PRELIMINARY/FINAL DRAINAGE REPORT

MIDTOWN COLLECTION AT HANNAH RIDGE

FILING No. 3

Engineering Review

DESIGNED BY	KRC	SCALE	DATE	08/21/20
DRAWN BY	KC	(H) 1"= 30'	SHEET	1 OF 1
CHECKED BY		(V) 1"= N/A	JOB NO.	1116.35

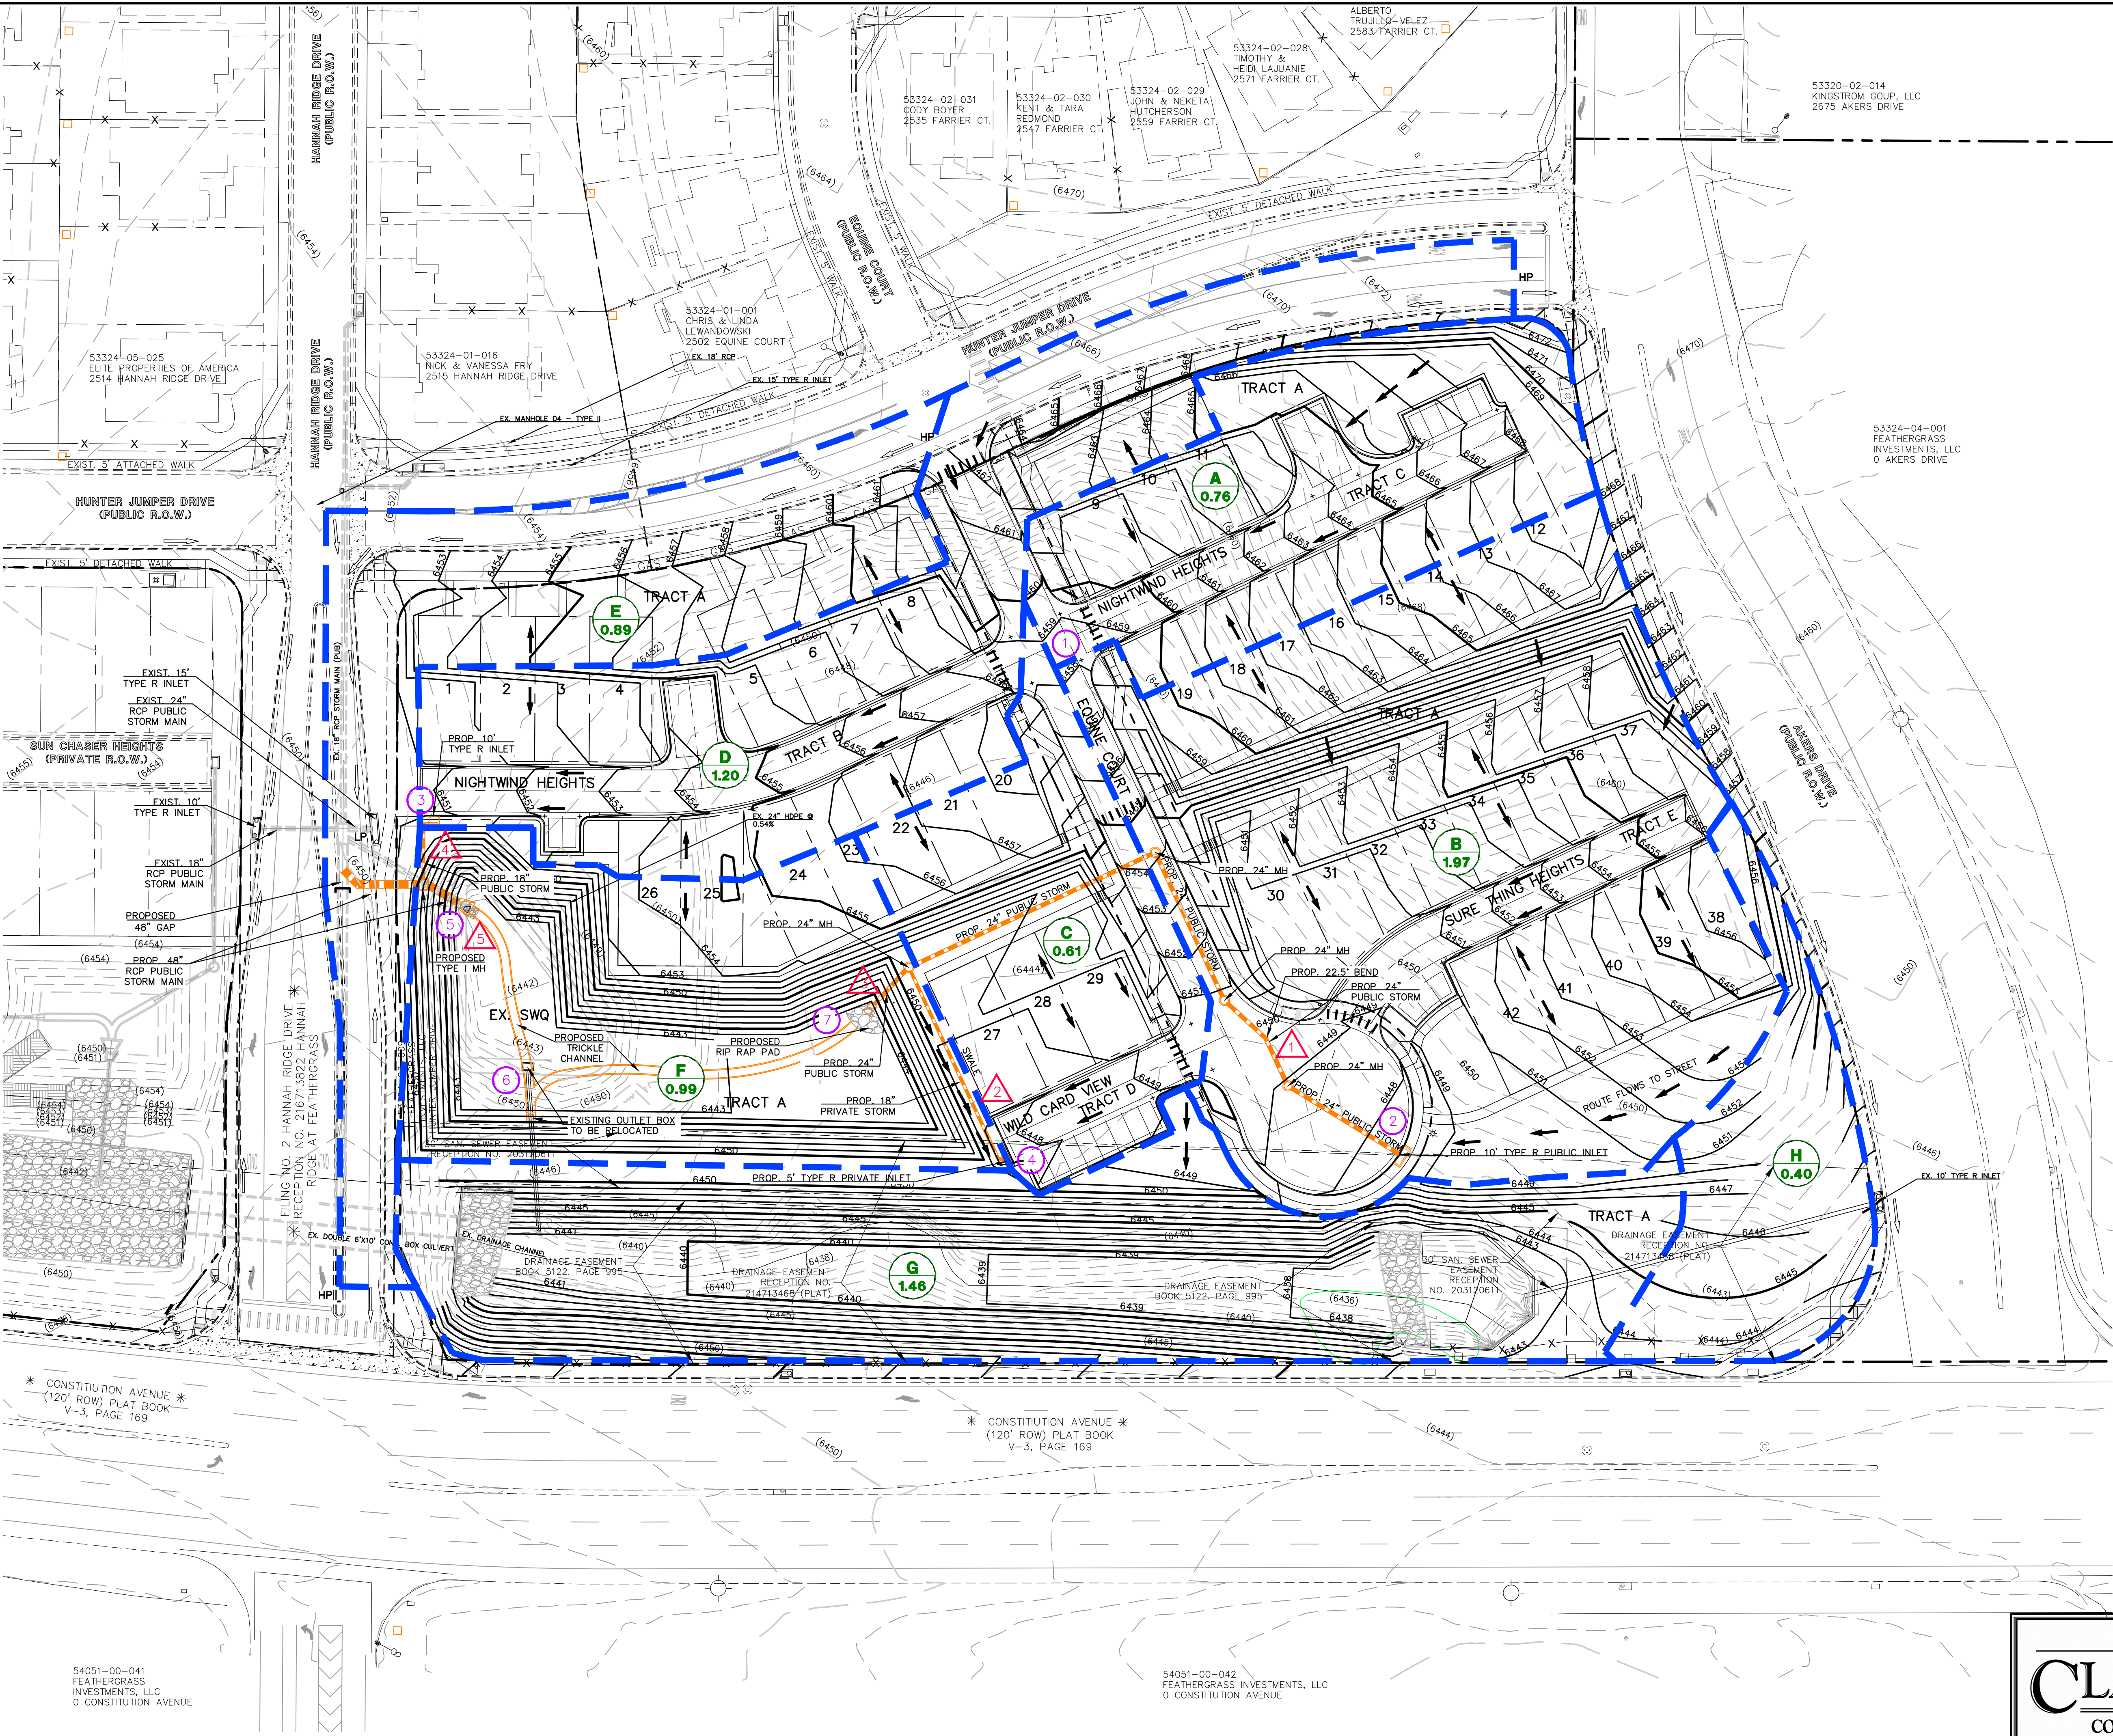
Plan shows public storm through HOA property to the proposed FSD

← south?

Basin H ($Q_5 = 0.2$ cfs and $Q_{100} = 1.3$ cfs) is a small 0.40-acre landscape parcel at the southeast corner of the site that street flows directly into Akers Drive and Constitution avenue. See redlines on basin line.
